Sussex Police
Serving Sussex

Date: 22nd March 2019

RE:- Cinder Lane, Nursery and Works to R/O Cinder Lane , Yapton BN18 0JJ

Thank you for your correspondence of 6th March 2019 regarding 'Approval of reserved matters following outline consent Y/5/17/OUT for 51 No dwellings. This application affects a Public Right of Way' for which you seek advice from a crime prevention viewpoint.

PLOTS 39-46 | GROUND FLOOR PLAN
 DEVELOPMENT AT:
 CINDERS LANE
 YAPTON
 BN18 0JJ

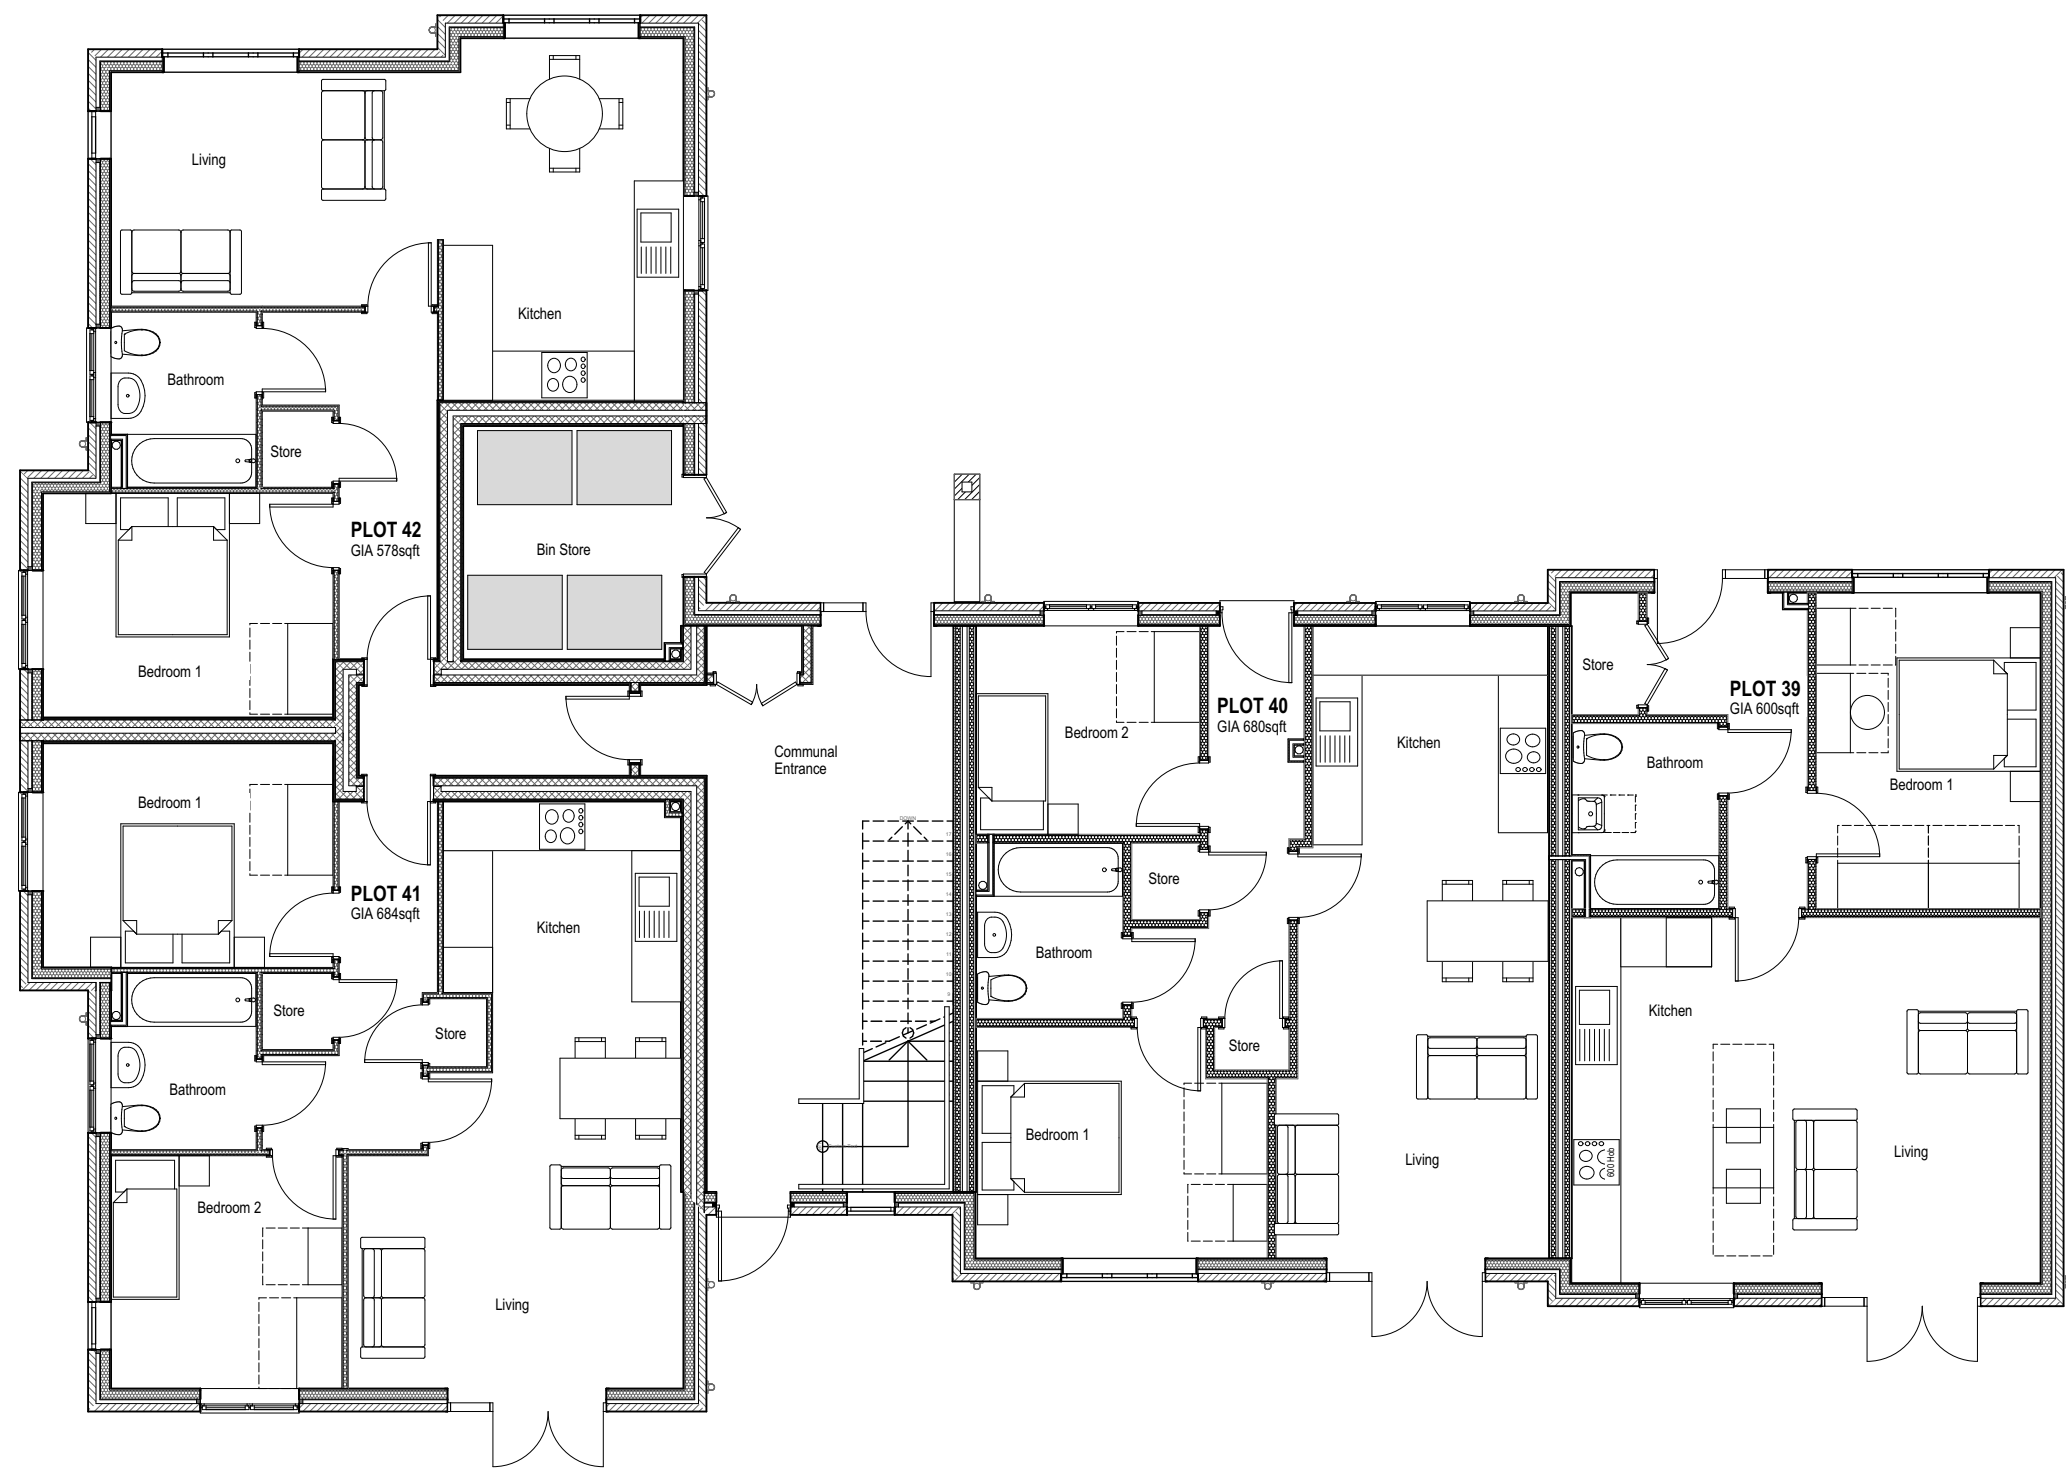
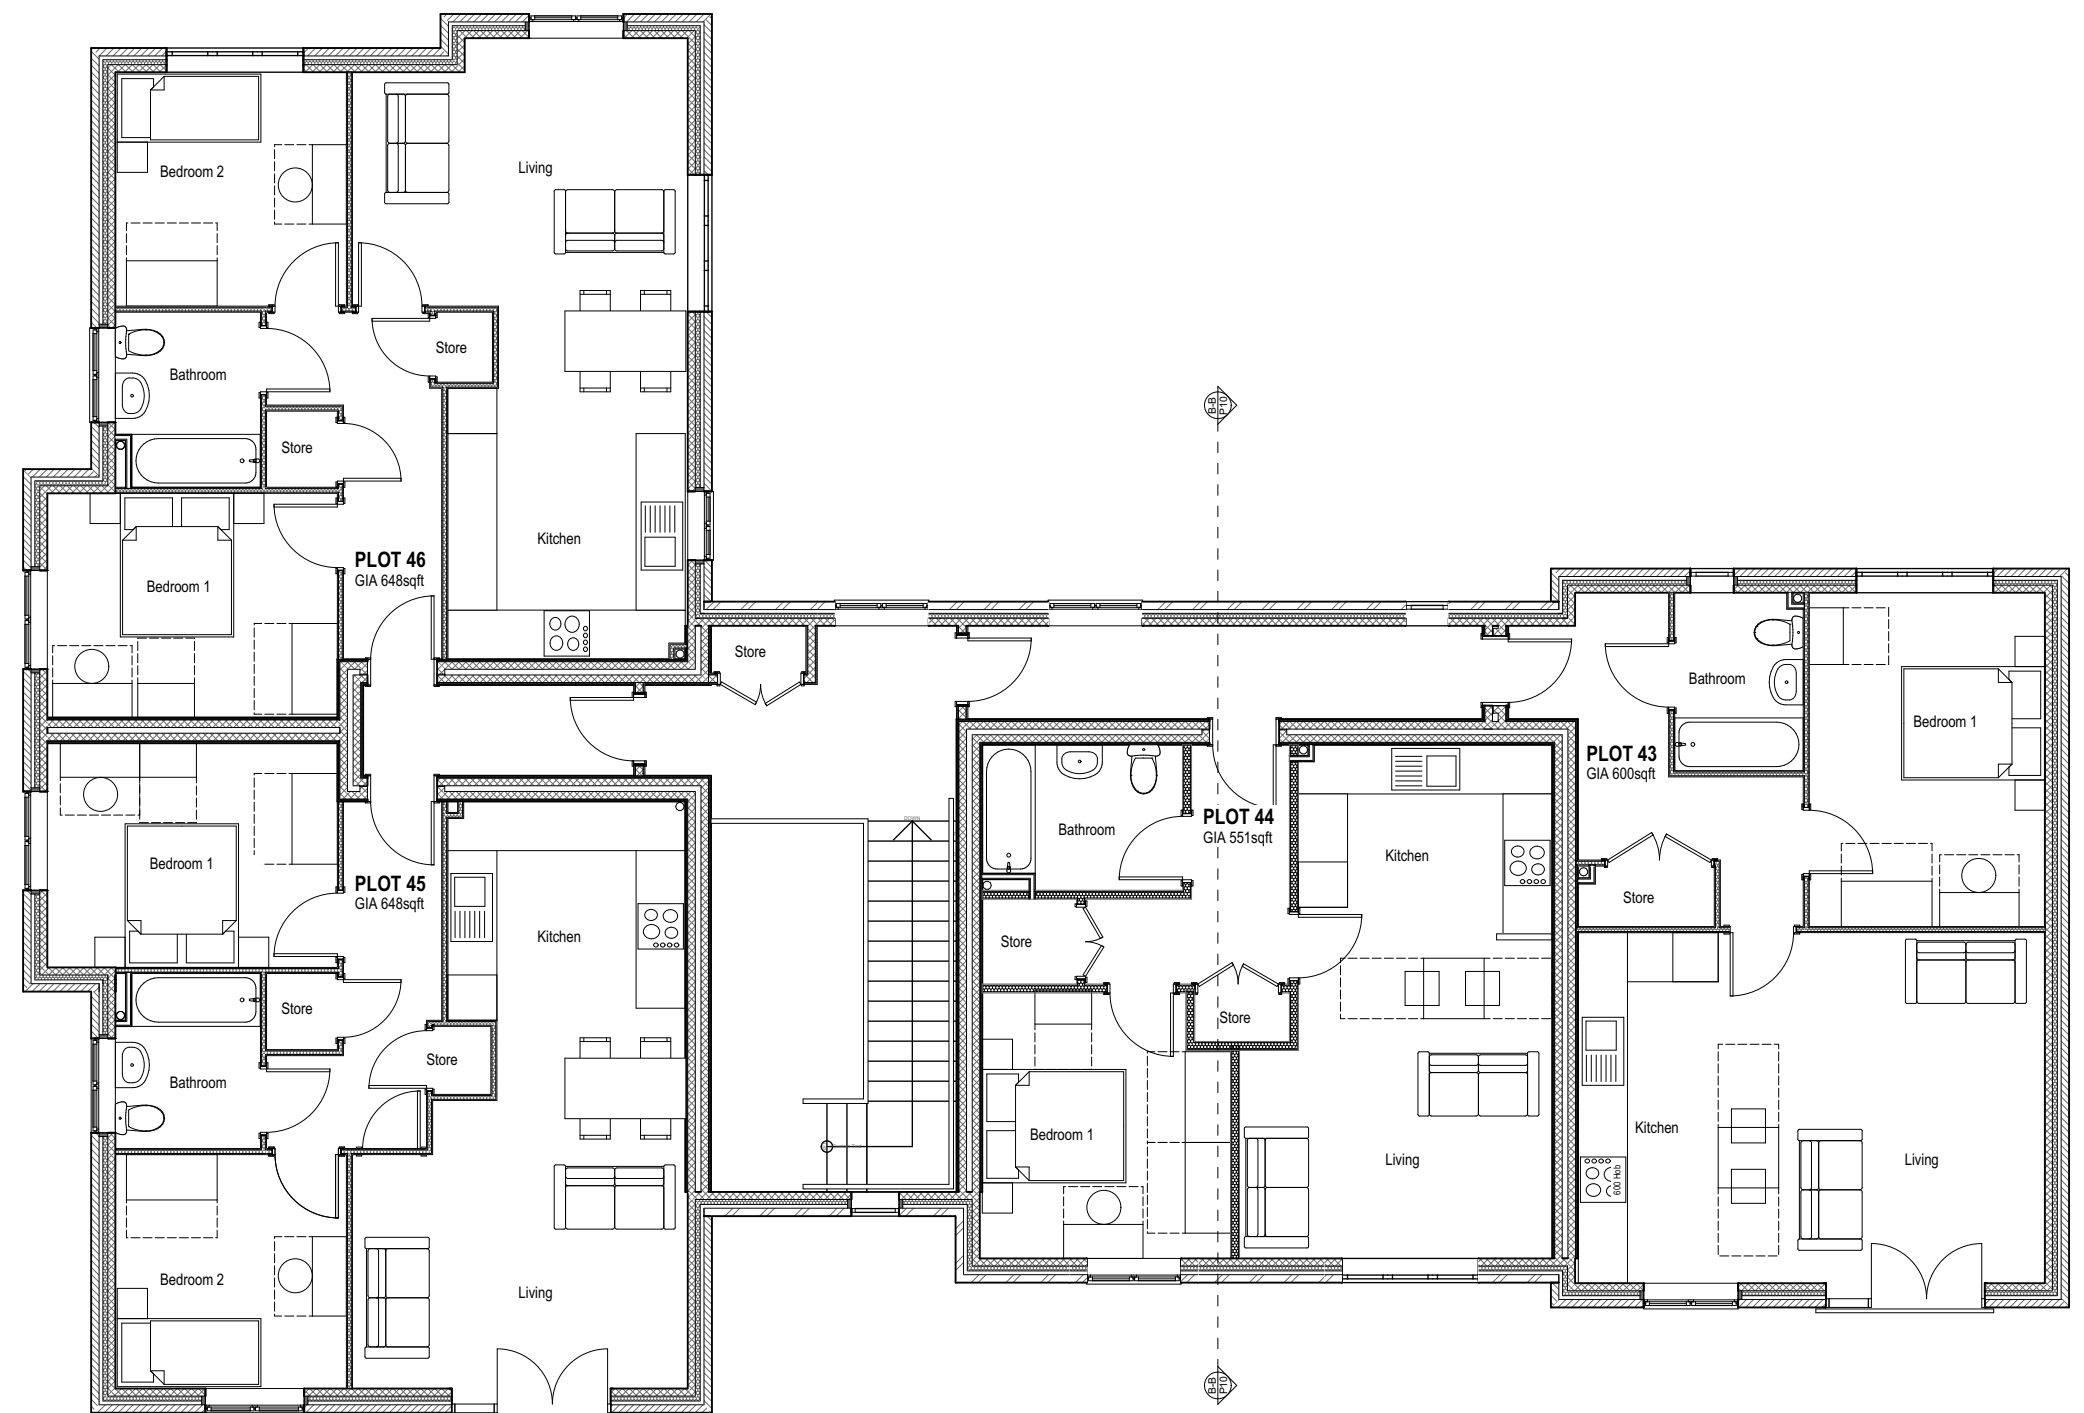
For the blocks of flats No's 40-47, SBD Homes 2019 Paragraph 27:10 to 27:13 gives recommendations for communal entrance door entry systems serving 5 dwellings or more but less than 10 dwellings.

Compartmentalisation of Communal dwellings (Flats 40-47)

I recommend that compartmentalisation is to be considered to protect the amenity of the flat residents. This will control the access from the stairwells where each resident is assigned access to the floor on which their dwelling is located via the use of a proximity reader, swipe card or key or door sets on each landing and can prevent unauthorised access to the corridor where their flat is located.

I recommend the postal arrangements for the flats are through the wall, external or lobby mounted secure post boxes. I strongly urge the applicant not to consider letter apertures within the flats' front doors. The absence of the letter aperture removes the opportunity for lock manipulation, fishing and arson attack and has the potential to reduce unnecessary access to the block.
